RE: SUBMISSION | SSD-10464 AT 50-52 PHILIP STREET, SYDNEY

This submission letter has been prepared by Paro Consulting on behalf of the Strata Plan Number: 03045 at 127-131 Macquarie Street, Sydney. This submission letter relates to the State Significant Development (SSD) development application SSD-10464 at 50-52 Philip Street, Sydney, which was submitted by the applicant Built. The SSD seeks approval for the staged delivery of a new landmark mixed-use luxury hotel and branded residential building. It is proposed to deliver approximately 246 new hotel rooms and 23 branded residential rooms. The assessment informing this submission, has relied on the publicly available documents on the online planning portal system.

### Proposed Podium

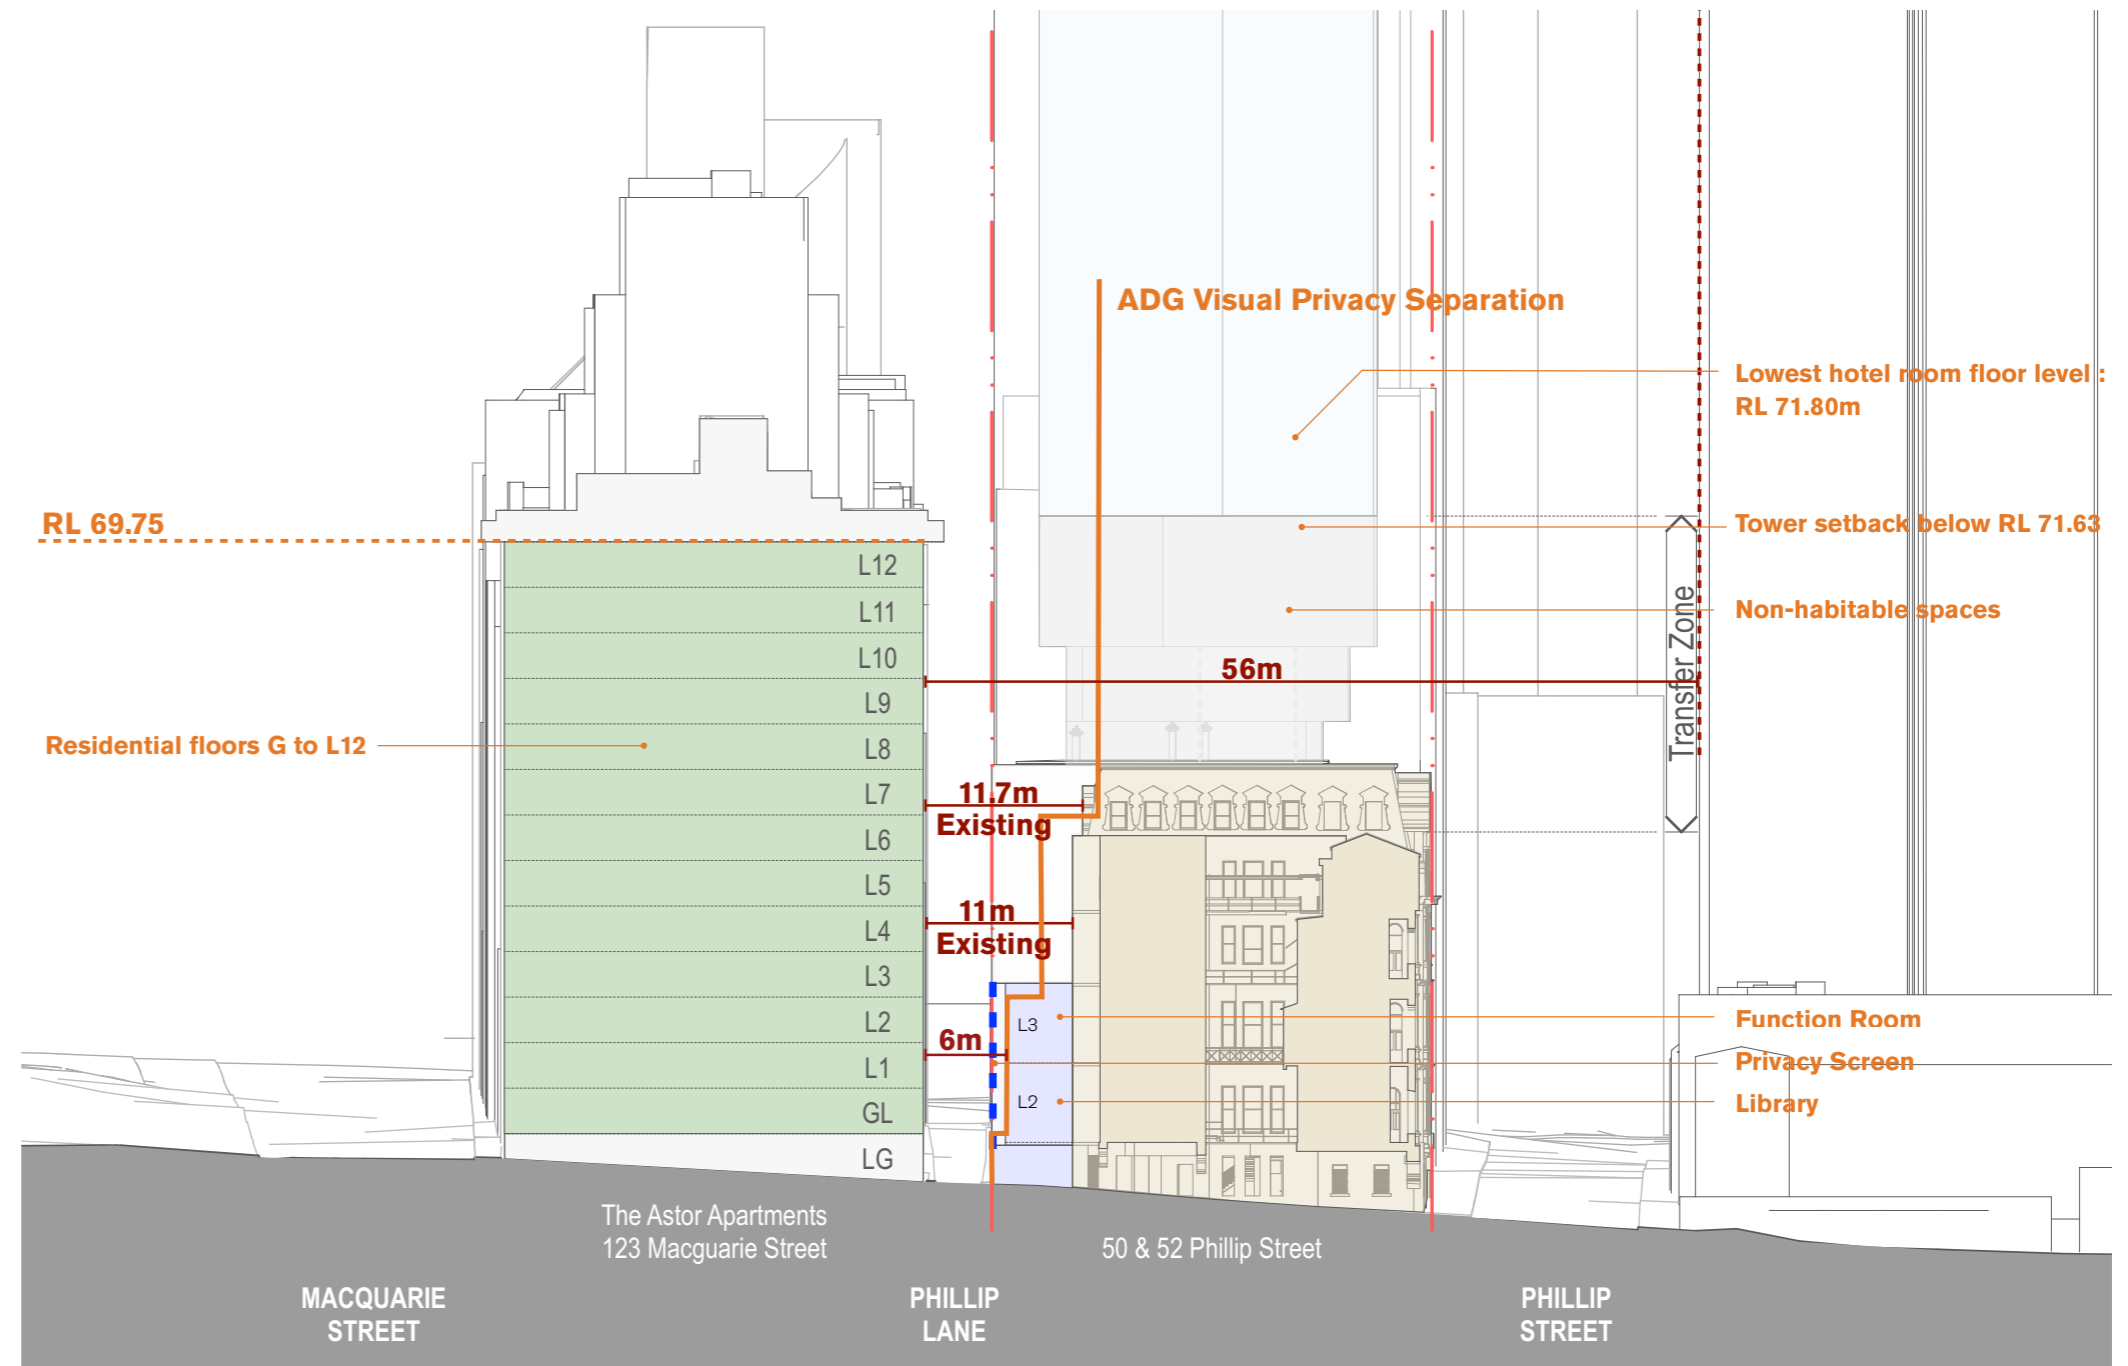
It is recommended that privacy measures are provided to the eastern elevation of the proposed function room to level 3 to prevent direct overlooking of the adjoining office tenancies at 127-131 Macquarie Street.

- It is recommended that privacy measures are provided to the eastern elevation of the proposed function room to level 3 to prevent direct overlooking of the adjoining office tenancies at 127-131 Macquarie Street; and
